DRB Application No.: 07DRB-70385 Project # 1006751  
Project Name:  
Agent: Bavelas CDC/COA Phone No.: 242-7888

**CITY OF ALBUQUERQUE  
PLANNING DEPARTMENT  
November 21, 2007  
DRB Comments**

**PROJECT # 1006751**

**RE: Tract 4, MRGCD Map 40/p&f**

**PLAT OF TRACTS A AND B LANDS OF IRMA AND JOSE LOPEZ**

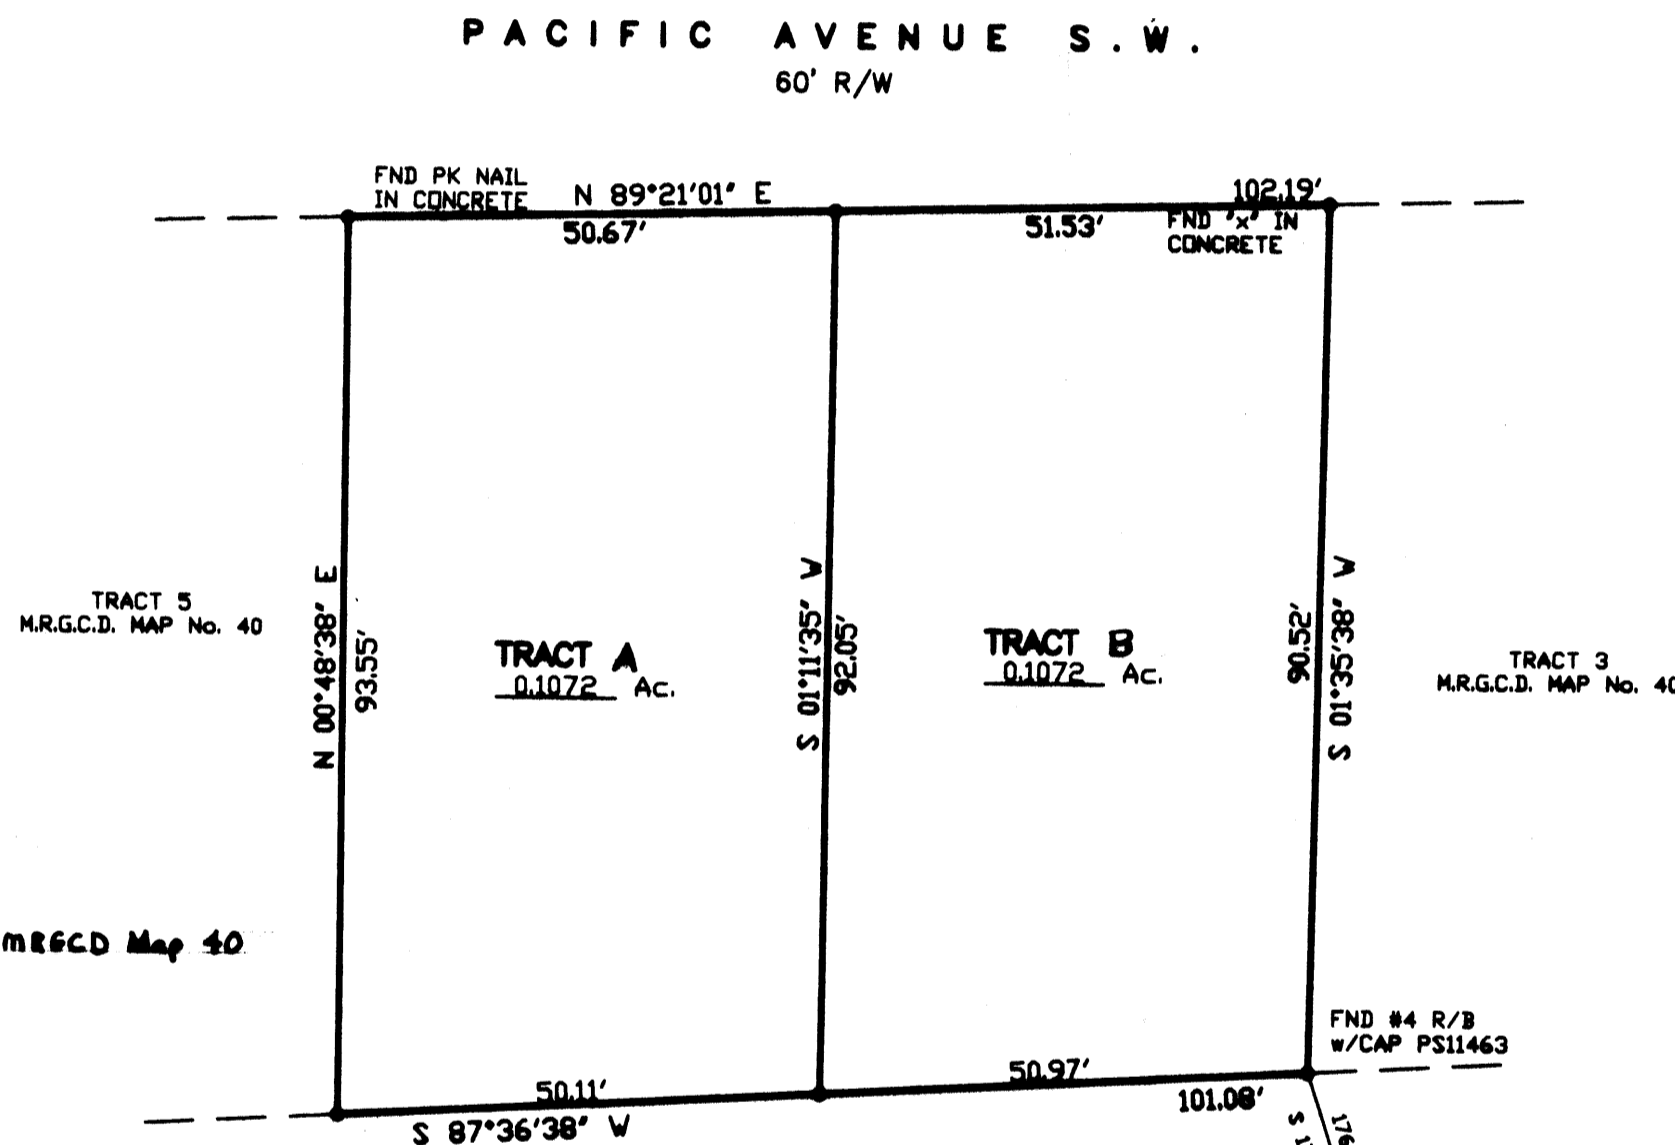
The AGIS dxf is not approved.

- 1) Infrastructure per the DPM is required.
- 2) What is the distance from face of curb to the property line? (It appears that dedication will be required)
- 3) A 6' sidewalk will be required.
